FP/110/20/PL

Re-fenestration of shop front

Proposed Shop Front Refenestration
at 82 Felpham Road, Bognor Regis
for Mr and Mrs R Pearse
Drawing P02 July 2020 Scale 1:100
Proposed Drawing - Ground & First Floor / Roof Plan & Elevations

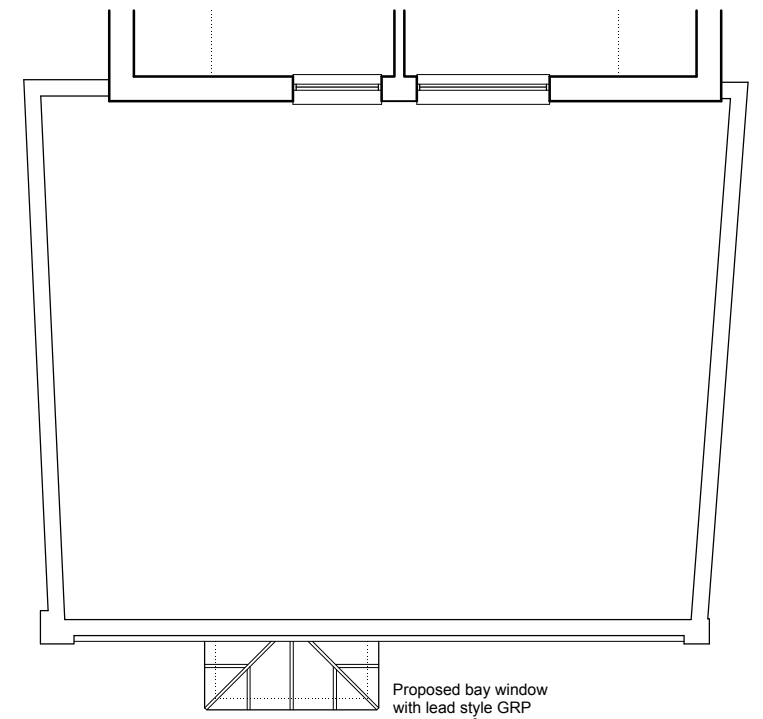
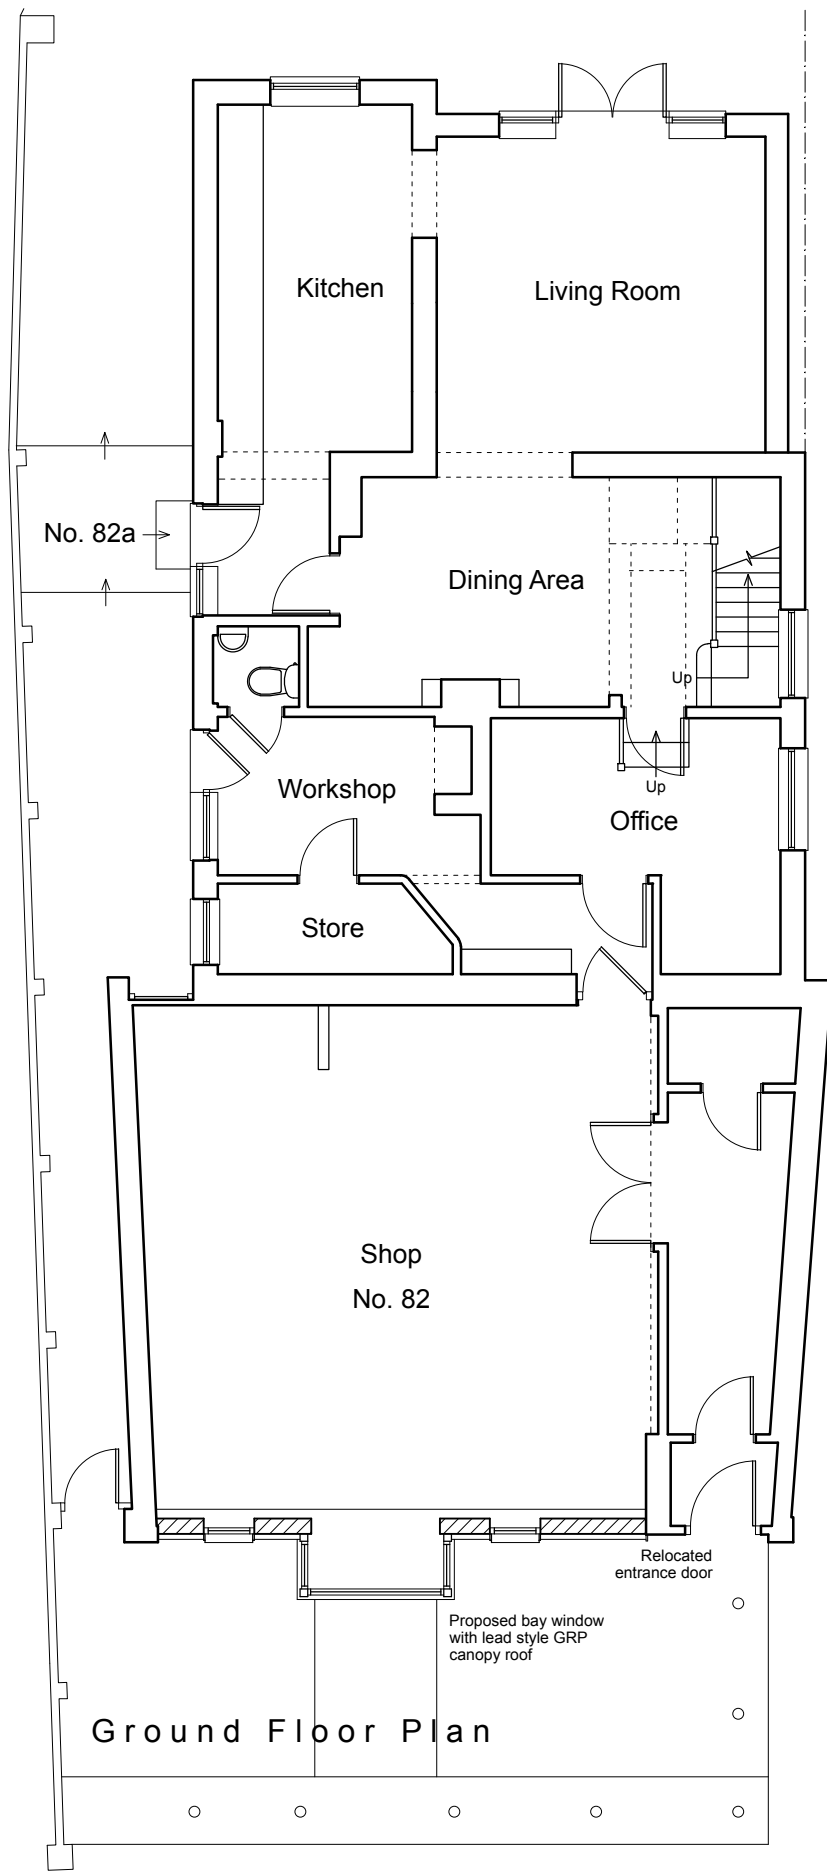
The proposal is for a new shop front which consists of two windows and a bay window, along with a new entrance door. The windows will be UPVC and will replace the existing aluminium shop front. There will also be horizontal composite cladding in the majority of the former opening.

Whilst the replacement shopfront/windows are generally acceptable, the use of materials is unfortunate. It is thought that the proposed development offers the opportunity to provide an enhancement to the elevation of the building and the setting of the conservation area. This is on the basis of more appropriate materials being proposed.

At present, it is considered that the use of materials means that the proposal is such that the impact can be described as causing less than substantial harm in accordance with paragraph 196 of the NPPF (2019). The level of harm is considered to be on the lower end of the scale.
